SUBJECT: **BRES2411-0036**  
**BUILDING RESIDENTIAL**

Here are the results of all Inspections located at **531 DUNCAN CREEK RD:**

FOUNDATION PLAN

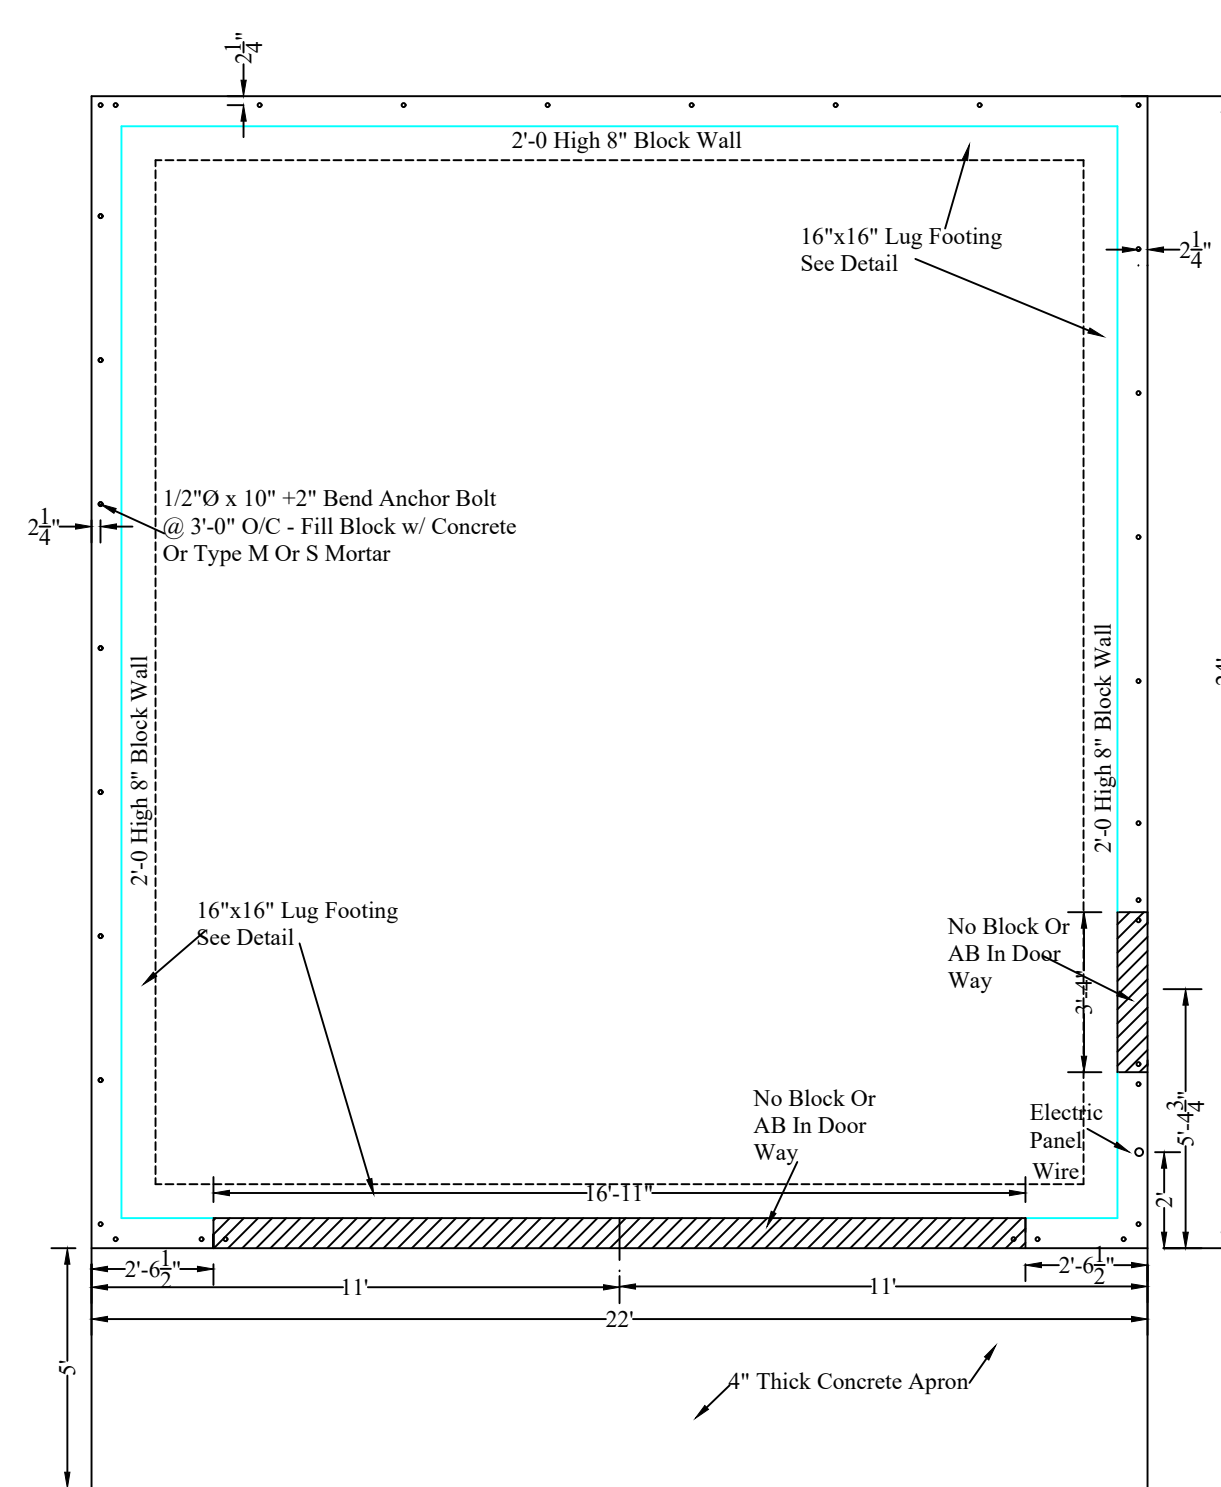
Inspection Type: MONO SLAB  
Scheduled Date/Time: 1/2/2025  
Completed Date/Time: 1/2/2025  
Inspector: Daniel L Floyd  
Result: DISAPPROVED  
Remarks:  
Notes: Not ready need plastic down and grade stakes Footing must be continuous around the whole building per plan Need rebar installed

Inspection Type: MONO SLAB  
Scheduled Date/Time: 1/10/2025  
Completed Date/Time: 1/10/2025  
Inspector: Daniel L Floyd  
Result: DISAPPROVED  
Remarks:  
Notes: Rebar bends must be continuous and overlap at least 24" for #4 rebar  
Rebar bends must be continuous and overlap at least 24" for #4 rebar No plans onsite Need plans onsite
